Written Submission for Deadline 8 providing commentary on Coastal Geomorphology

Response from the Alde and Ore Association (Registered Charity number 1154583)

IP REF:20026276

Figure 14 The loss of sediment volume from the BfE storm in 2099 with receded lateral shorelines (left) and the remaining sediment volume of the SCDF after the BfE storm (right).

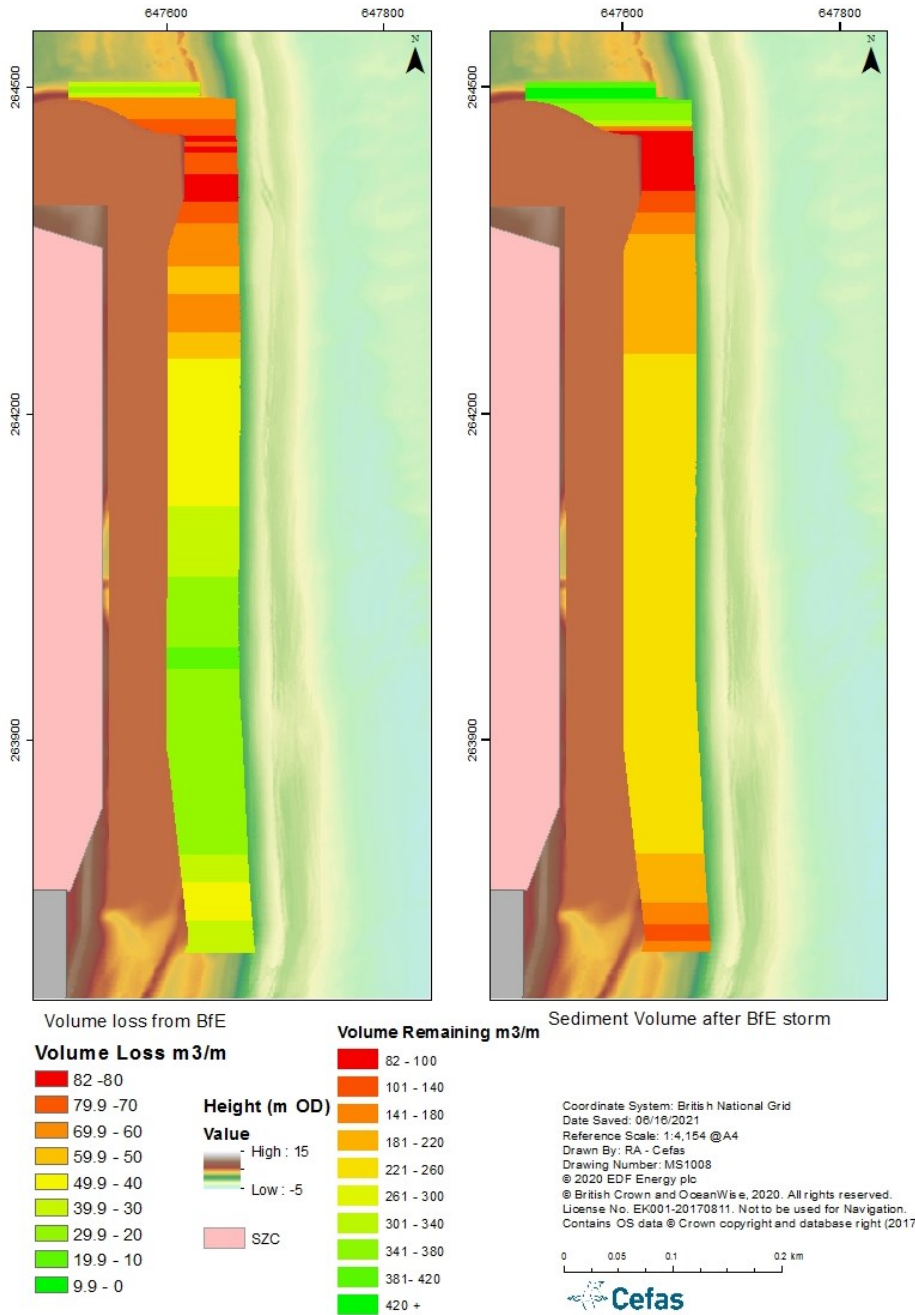
Coastal changes- natural and due to constructions: Page 56 of REP7-101 shows losses in 2099 (receded shoreline sediment losses) and how they will increase over the years. The Applicant said the figures did not include natural recovery but the fact remains that this coast normally experiences huge variation over the years, e.g. this last winter parts of the coast lost over a metre in depth of shingle in a few storms and while some of it may return, the more the interference by new construction on the coastline the harder for natural processes to return to their natural course.
